**ADC PARKS & GREENSPACE ARBORICULTURE CONSULTATION**

PLANNING APPLICATION: AW/85/12/T

ADDRESS: Headland House Strange Garden Estate Bognor Regis

BRIEF DESCRIPTION: Remove 3 metres from crown of 1 no. Twisted Oak tree which is hollow. Trim 1 metre from crown of 1 No. Twisted Oak beside it.

Tree that is hollow and needs  
3 m trimming from crown.

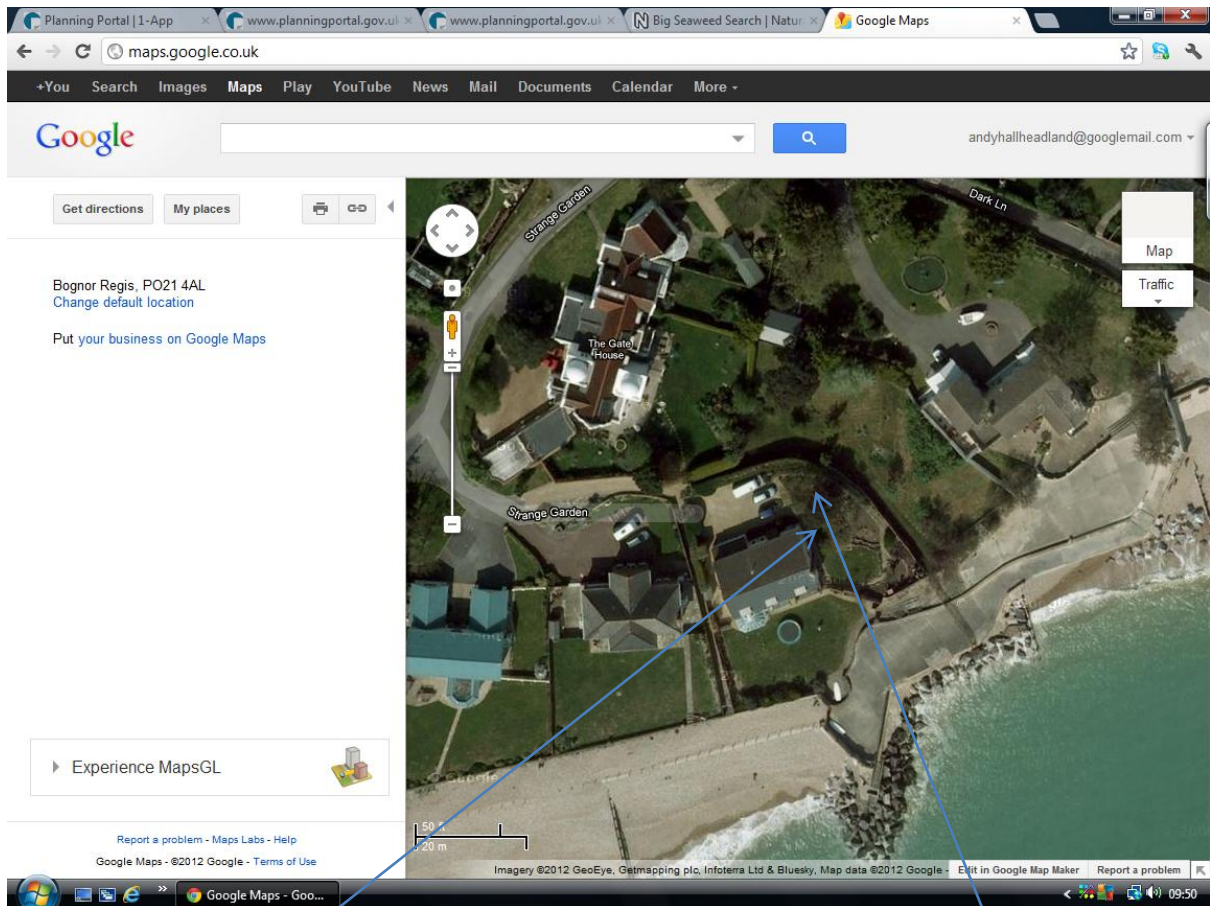
I have visited the site and inspected the two Oak trees. Due to the nature of the pruning request the proposed work is acceptable and the pruning should accord with good Arboricultural practice in accordance with BS 3998 (2010). I have provided a suggested Condition, below..

- The Crown Reduction should not exceed the removal of branch lengths greater than **3m** from the hollow Oak tree nearest the property and **1m** from the 2<sup>nd</sup> Oak tree affected by Squirrels.
- All pruning cuts must leave healthy leaf bearing side branches where possible which are **1/3<sup>rd</sup>** or greater in diameter of the removed branch.
- Pruning cuts must be flat and smooth, kept as small as possible and cut at an optimum angle leaving the branch collar intact.
- Pruning wounds of removed branches must not exceed **100mm** in diameter.
